# FOREST HEIGHTS ESTATES GRADING & EROSION CONTROL PLANS

FOR FOREST HEIGHTS CIRCLE  
COUNTY OF EL PASO, STATE OF COLORADO

**FOREST HEIGHTS CIRCLE GRADING & EROSION CONTROL PLAN**  
GENERAL NOTES AND EROSION CONTROL DETAILS

FOREST HEIGHTS CIRCLE
GRADING & EROSION CONTROL PLAN
GENERAL NOTES AND EROSION CONTROL DETAILS

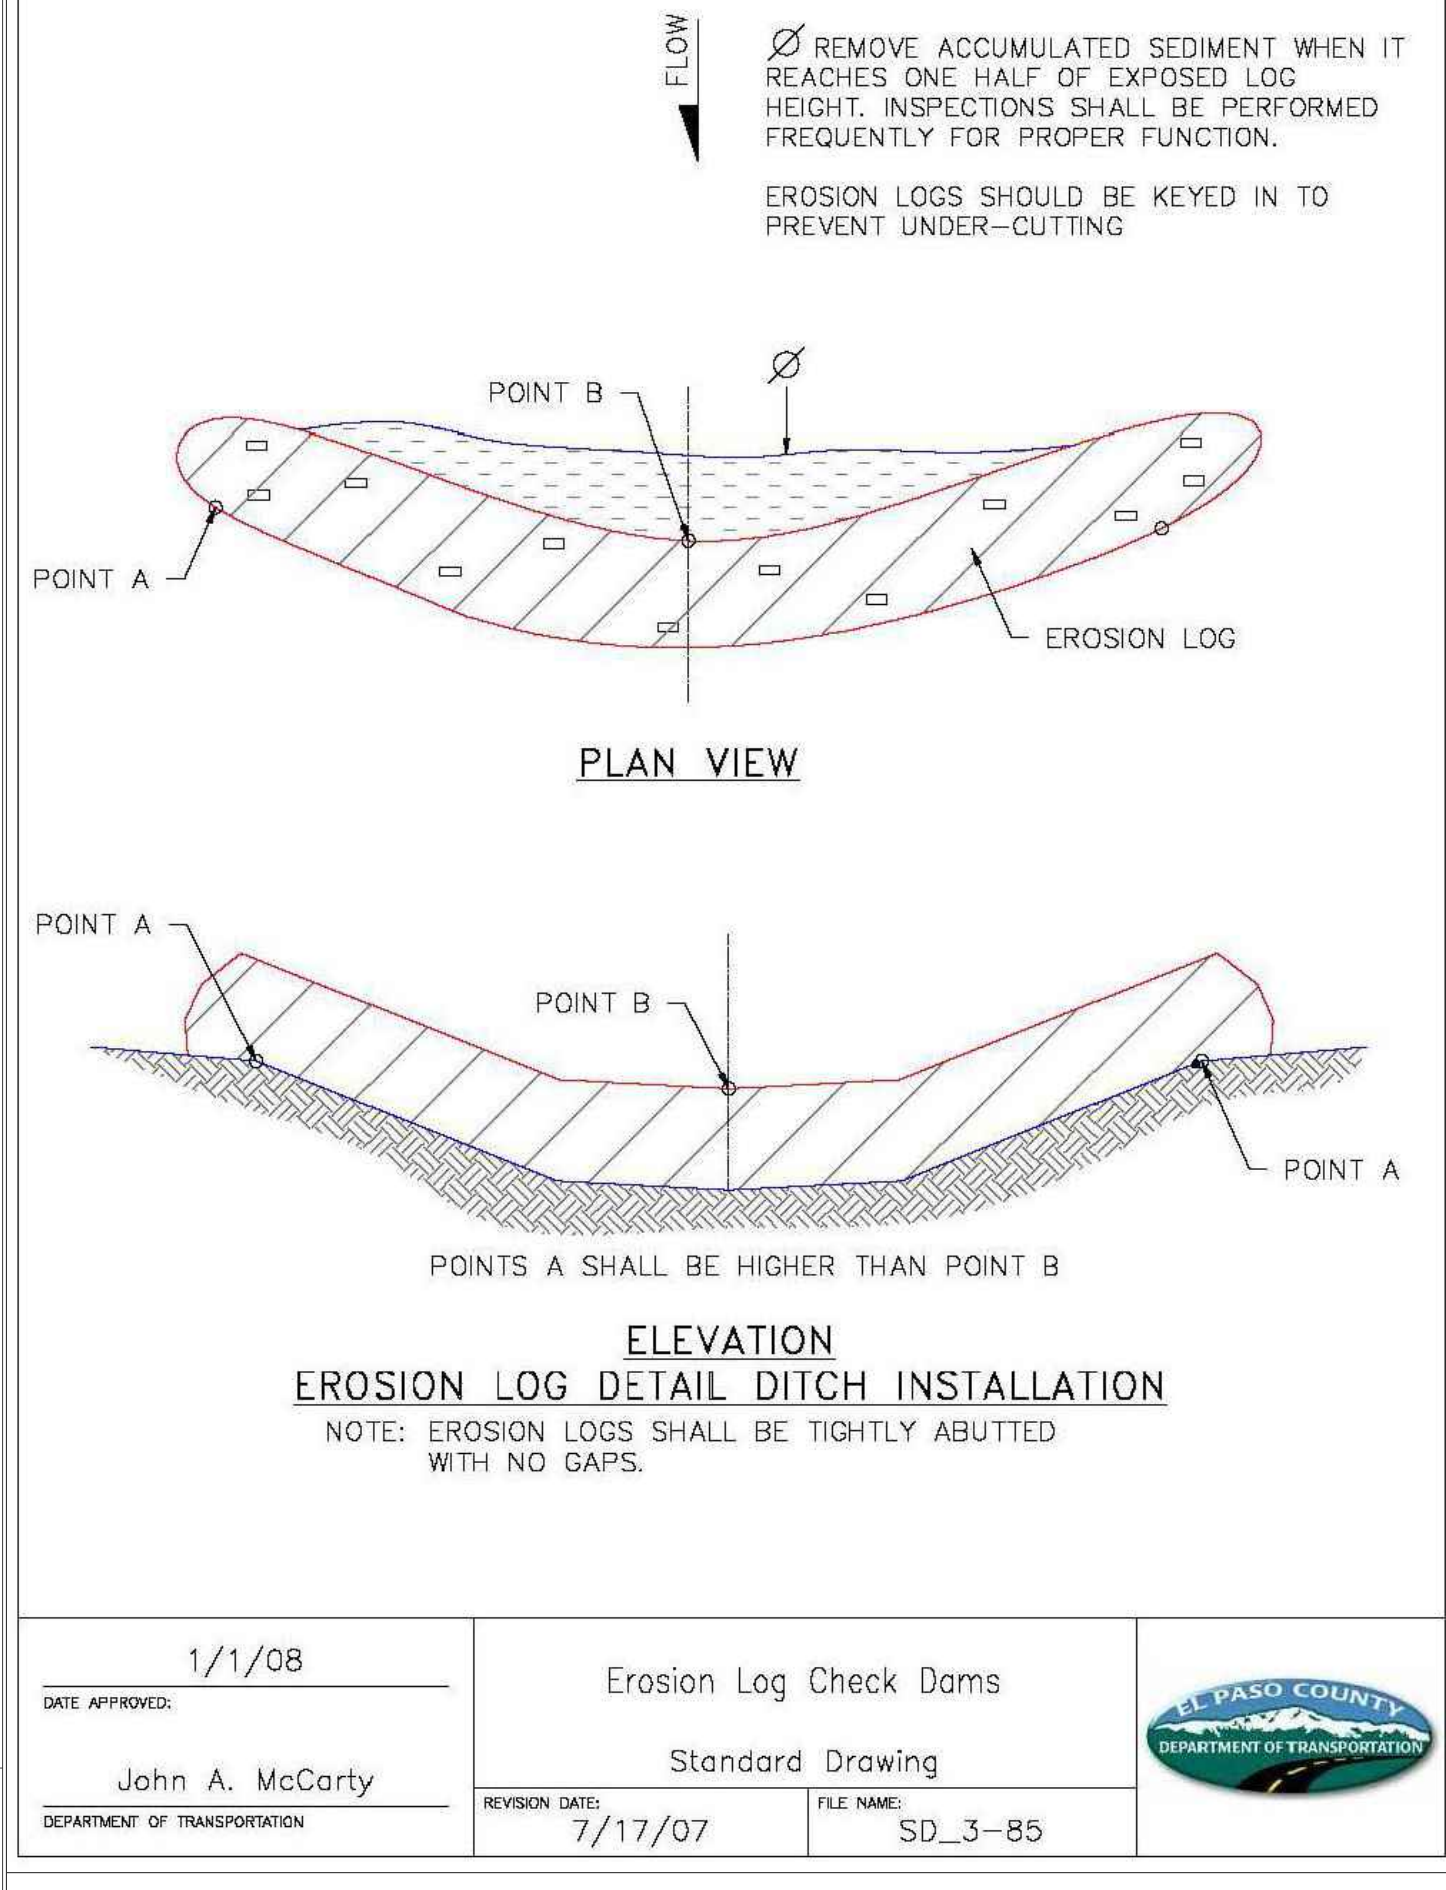
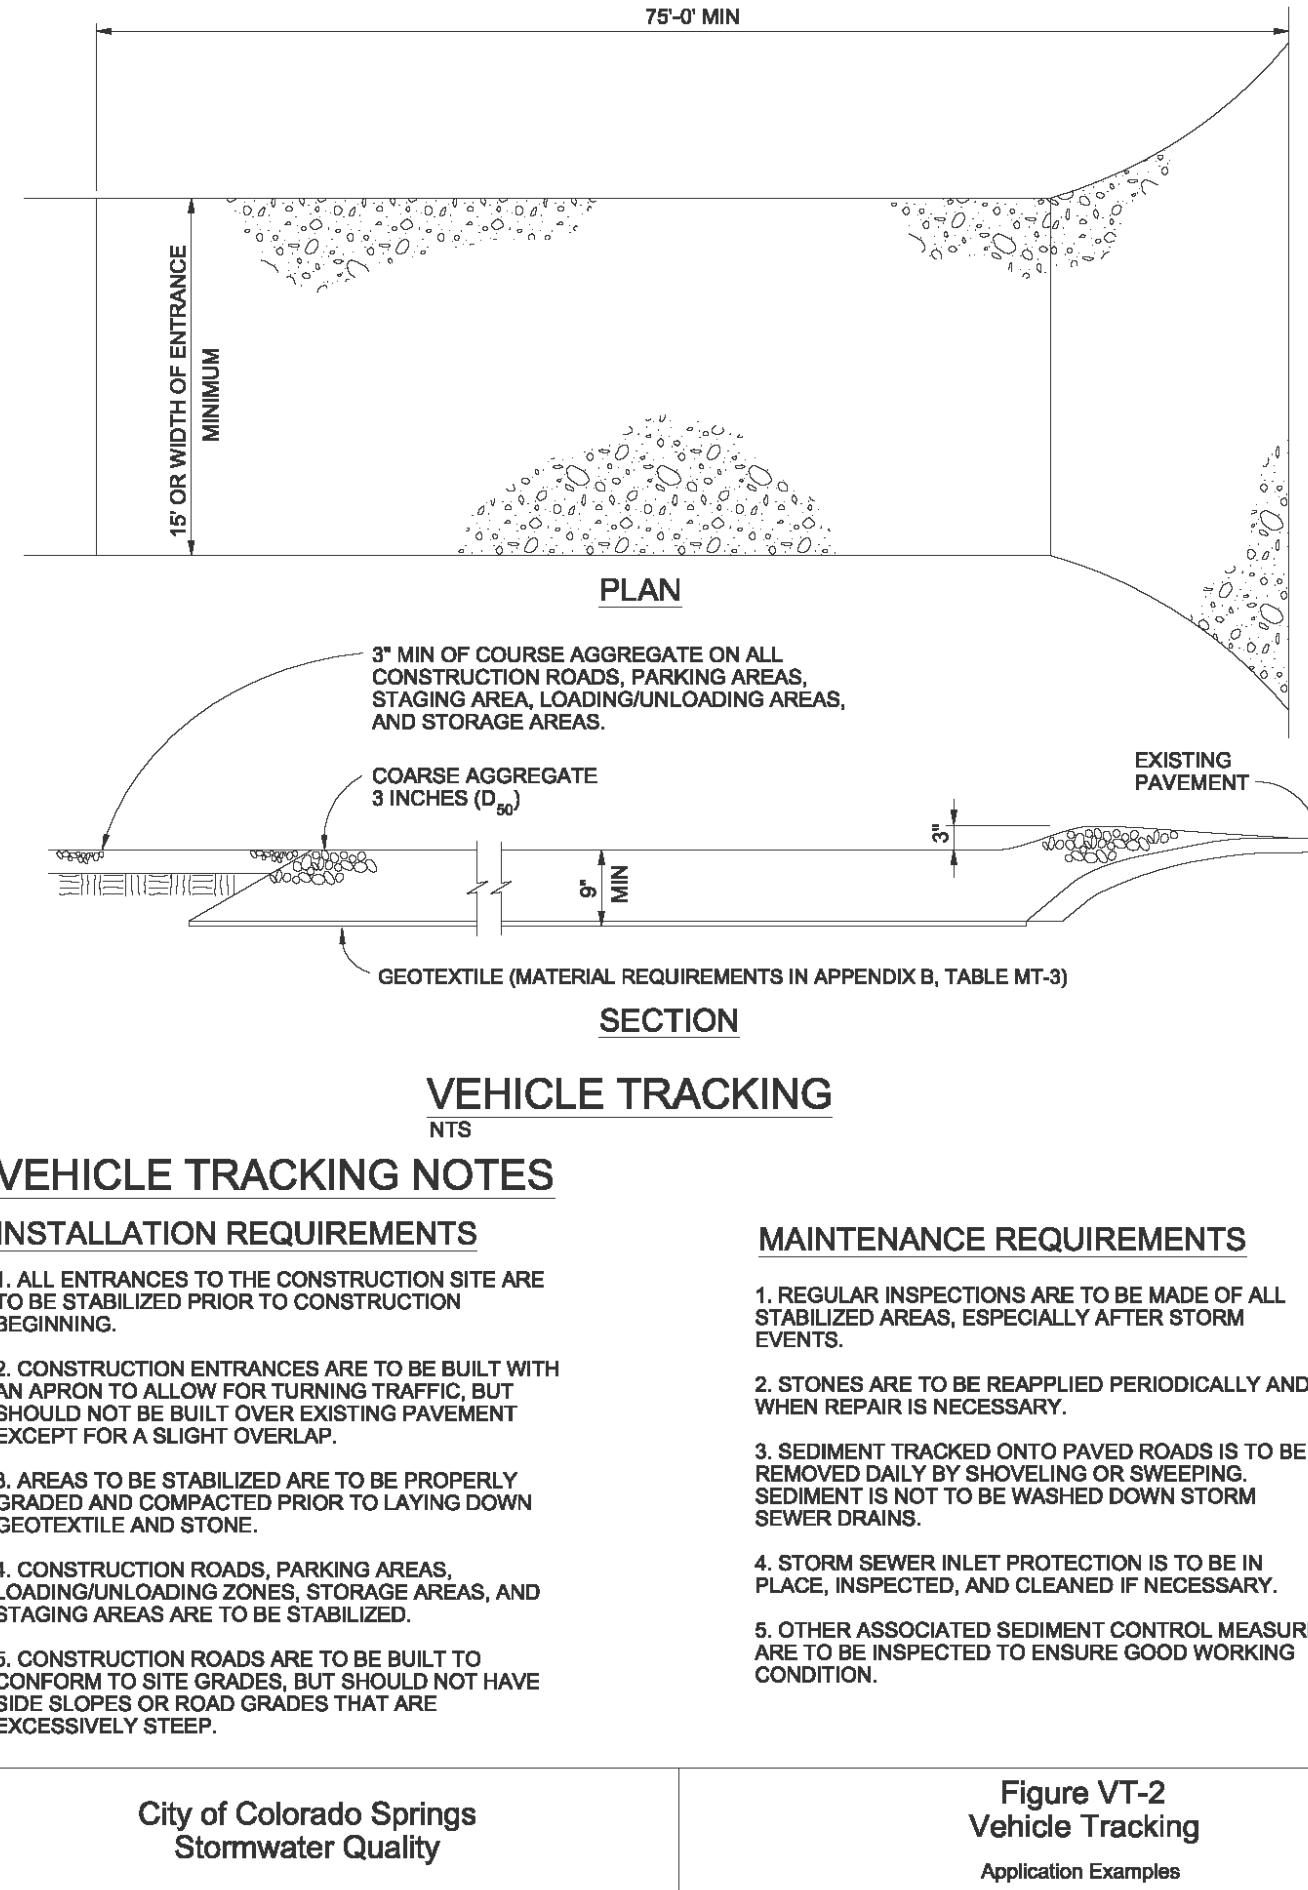
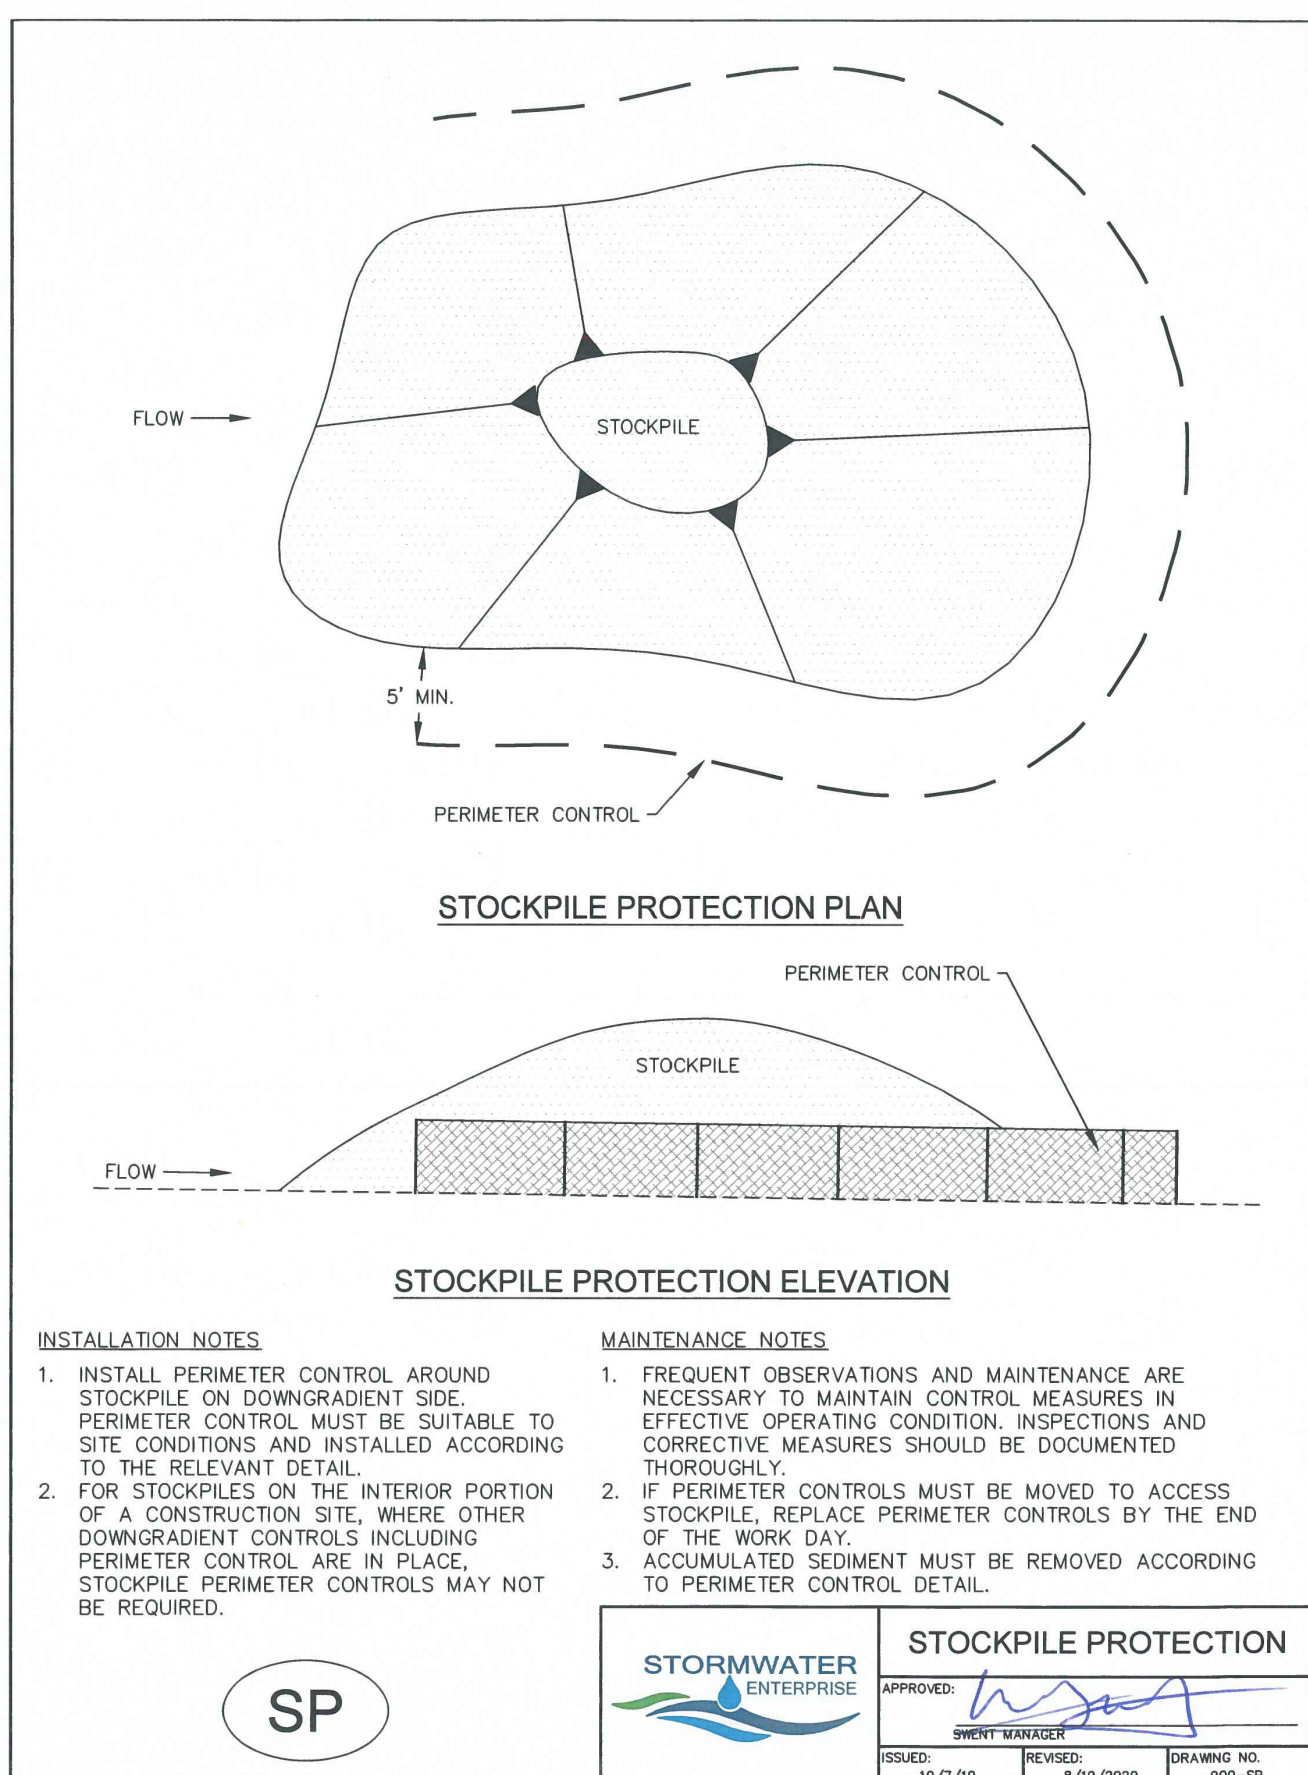
does not match note on Sht 4 below. Revise to remove discrepancy.

Unresolved previous comment from Review #2: If a VTC is added to the plans above, add a VTC detail to this sheet. And make sure to use a EPC approved VTC detail (VT-1 and VT-2 in DCM V2, Chap 3.3) or revise other detail (which usually have 50ft length) to be 75ft min length.
